SSD-9679 for Hills of Gold Wind Farm at Morrisons Gap Road, Crawney

14 December 2022

TfNSW has reviewed the amended application and supporting documentation submitted and **is not satisfied** that the proposed development has adequately addressed the anticipated construction traffic impacts to ensure that the new access routes can provide safe and practical access.

Figure 3: Route 2 Nundle Bypass

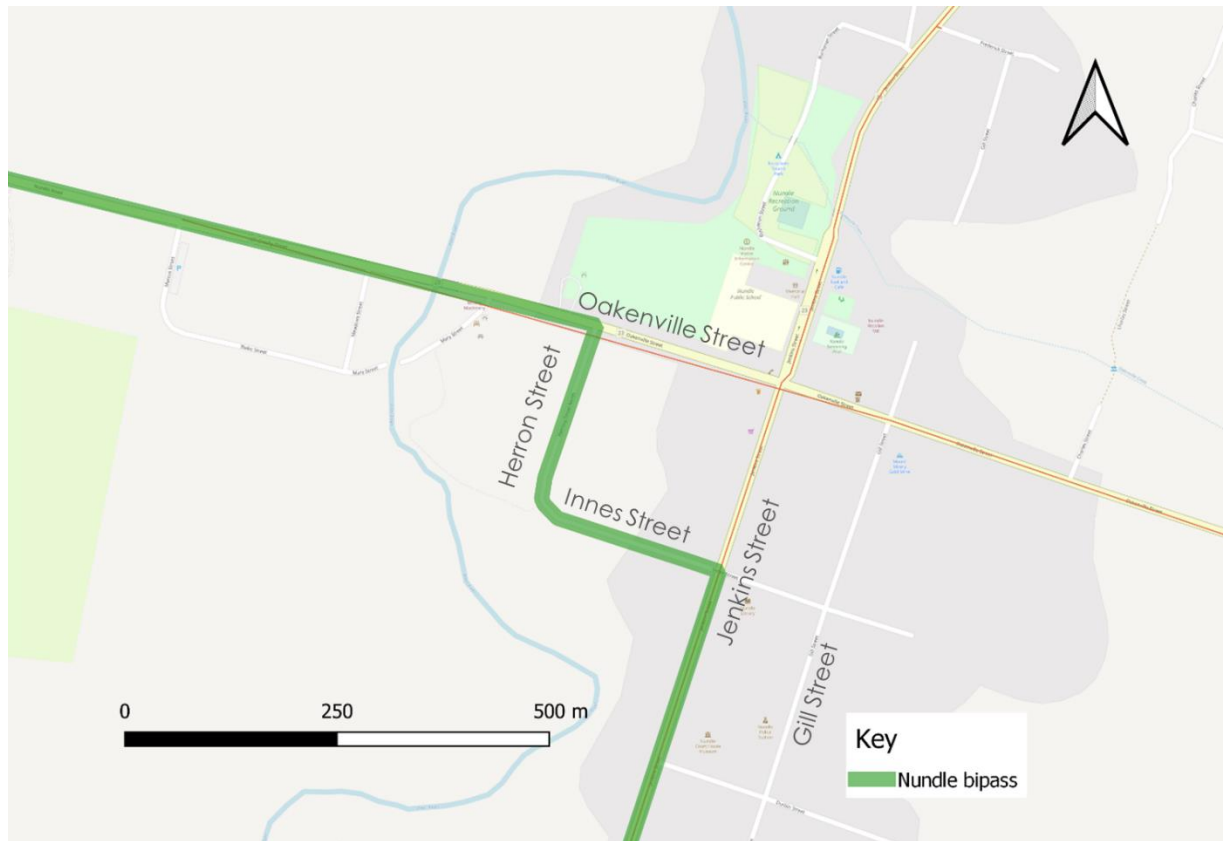
- Proposed to divert large vehicles from Oakenville Street onto Heron Street North and Innes Street and then a right turn on to Jenkins Street and Crawney Road.

- It is noted that 35 % of the construction traffic and OSOM vehicles (excluding blade routes) are proposed to utilise this route, however it is noted, an option in Figure 4, presents an Alternative Blade Route (Option 2) to the Route 1 Loop.
- This route will require TfNSW concurrence under Section 138 of the Roads Act 1993, for any works at the intersection of Oakenville Street (MR105) and Heron Street North, the details of which remain unclear.

- Insufficient information has been provided regarding the proposed Nundle Bypass via Route 2:
 - No swept paths have been provided for the largest construction design vehicles at the key intersection.

- What the existing general road geometry (including turn treatments) is at the key intersections for Route 2.
- Whether the intersections are currently capable of accommodating two-way movements of heavy vehicle at each leg of the key intersections, in particular during concurrent opposing heavy vehicle turn movements
- If an upgrade of the intersections is required to accommodate an increase in traffic and the swept paths of the design vehicles and the extent of that work if applicable.

- Provide a scaled strategic design of the Nundle Bypass between Oakenville Street and Jenkins Street. The updated plans are to demonstrate the scope of works required for any potential upgrade to the Oakenville Street & Heron Street North intersection. Including but not limited to the provision of:

- The extent of the proposed works, including permanent and temporary footprints, including but not limited to the provisions of any turn treatments, road widening and hardstand areas.

- Any turn treatments, designed and constructed in accordance with the relevant *Austroads Guidelines*, *Australian Standards* and related *TfNSW Supplements*, demonstrating all relevant line-marking, lane & shoulder widths.

- Building or tree removal, relocation of utilities, stormwater management, and signage etc.
 - Safe Intersection Sight Distance (SISD) requirements in accordance *Austroads Guide to Road Design Part 4A* are achieved in both directions at the intersection with Oakenville Street.

- Dedicated swept path diagrams, clearly identifying the size & type of the relevant design vehicles, the swept path of both the wheel base, any vehicle (load) overhang and stationary vehicle positioning, demonstrating the largest (construction) design vehicle will be able to safely and efficiently arrive and depart the key intersection in both directions to access the site, travelling wholly within the required travel lanes and clearly identifying where applicable, any additional works required to accommodate those vehicles.

Figure 4: Alternative Blade Route (Blade Option 2)

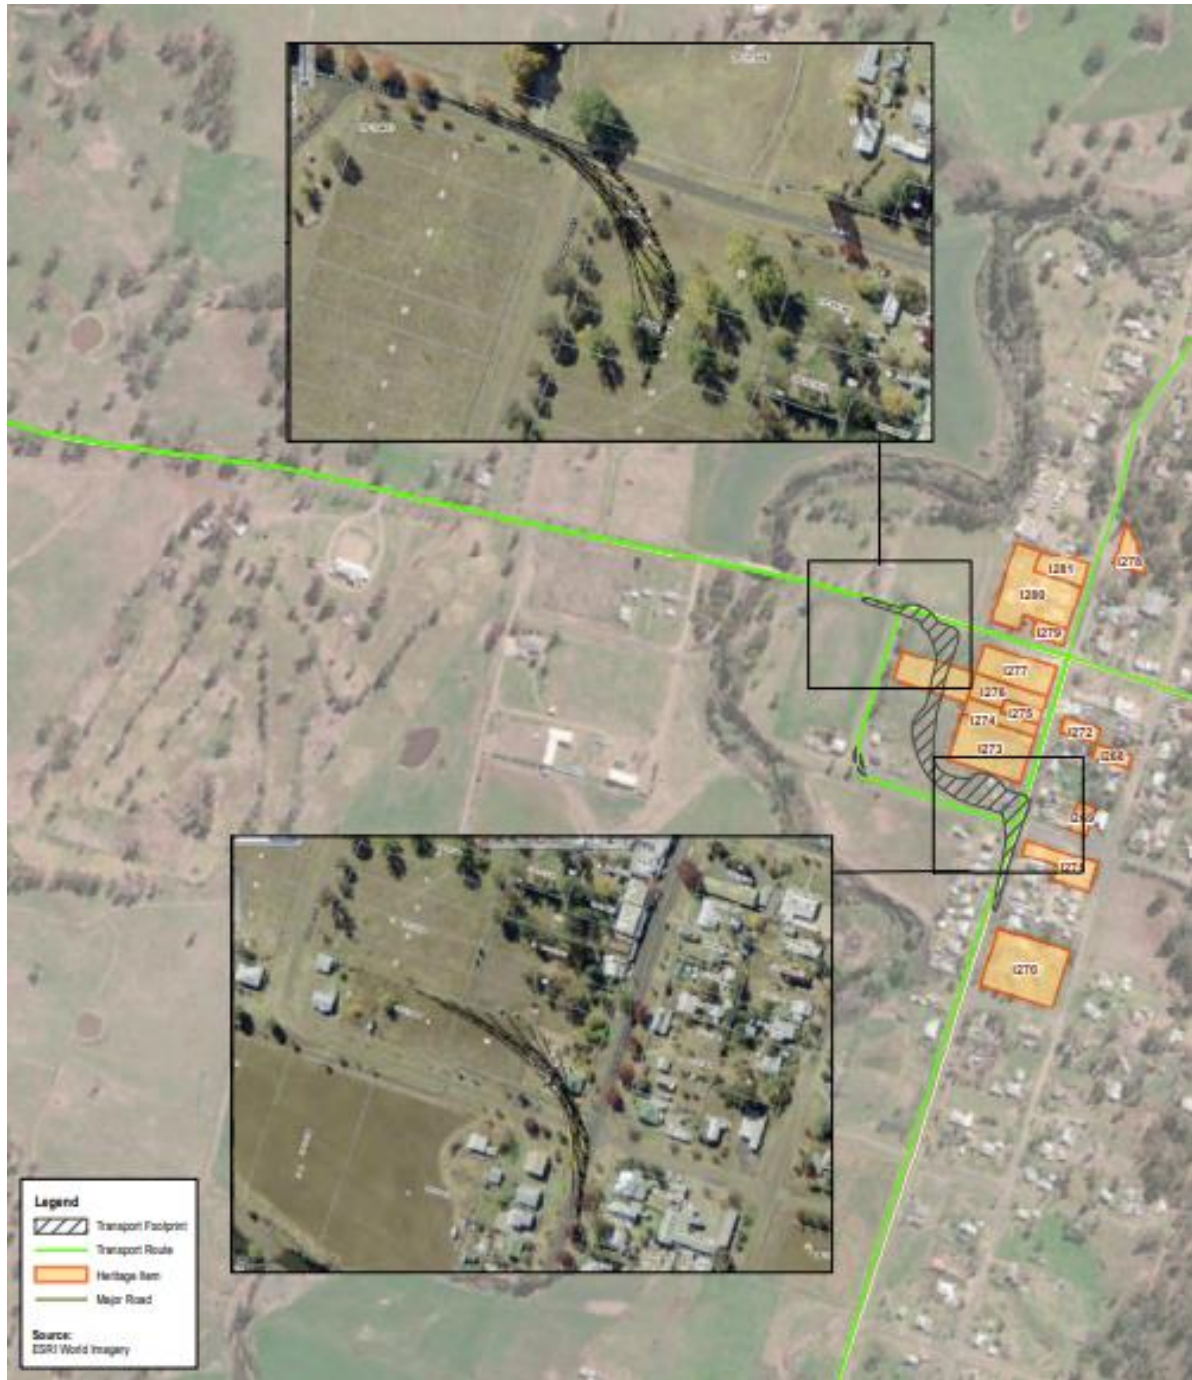
- The OSOM swept paths provided for the Alternate Blade Route provided in the TIA, Route Survey and Amendment Report are considered to be incomplete, as they are presented in segments only and in some cases do not appear to align with adjacent movements. It is understood that this proposed option is under investigation, however, as this proposal may impact any Section 138 approvals and TfNSW's concurrence, and any associated environmental approvals are required to be identified & addressed prior to determination.

- Over Sized Over Mass (OSOM) swept paths should demonstrate the single movement from Oakenville Street through to Jenkins Street. Further demonstrate any pull-over bays required to undertake the movements and any required traffic control processes, where applicable, to enable the required turn movements.
